From: Richard Temple
Sent: 26 October 2017 09:18
To: Planning.Responses
Subject: FW: EG/72/17/DOC

From: Richard Temple
Sent: 02 October 2017 09:57
To: Ben Kirk [REDACTED]
Subject: EG/72/17/DOC

Please find below the response from our Drainage Engineer regarding the above condition:

From: Paul Cann
Sent: 27 September 2017 16:18
To: Planning.Responses
Subject: RE: Planning Consultation on EG/72/17/DOC

Ground Floor Plan
Surface Water Drainage

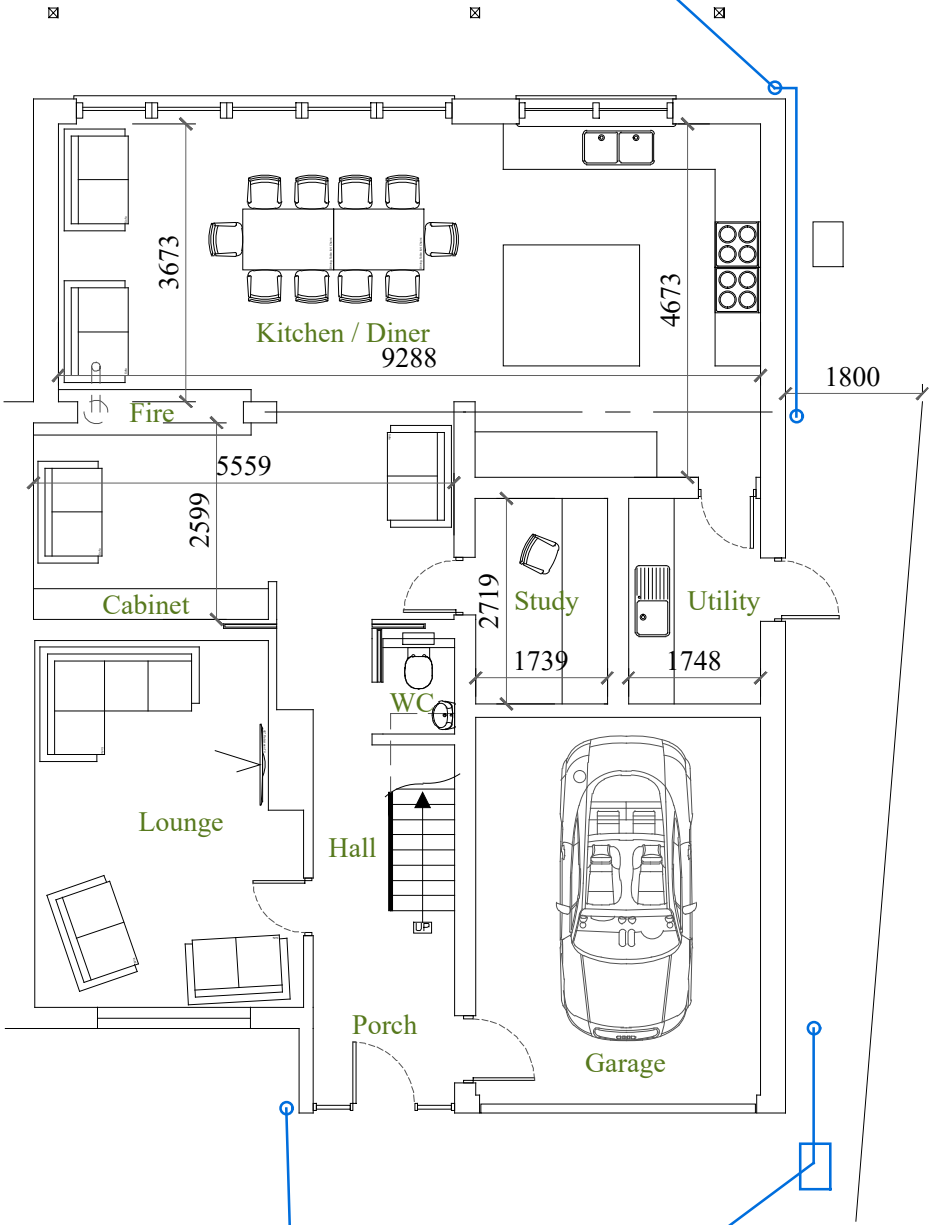
The applicant does not appear to have investigated winter groundwater levels or undertaken winter percolation testing at an agreed depth/location. If soakaways prove feasible, then new soakage structures will be required to serve the new extensions. Discharge into existing soakaways will not be permitted.

The detailed design will need to be supported by hydraulic calculations/construction details.
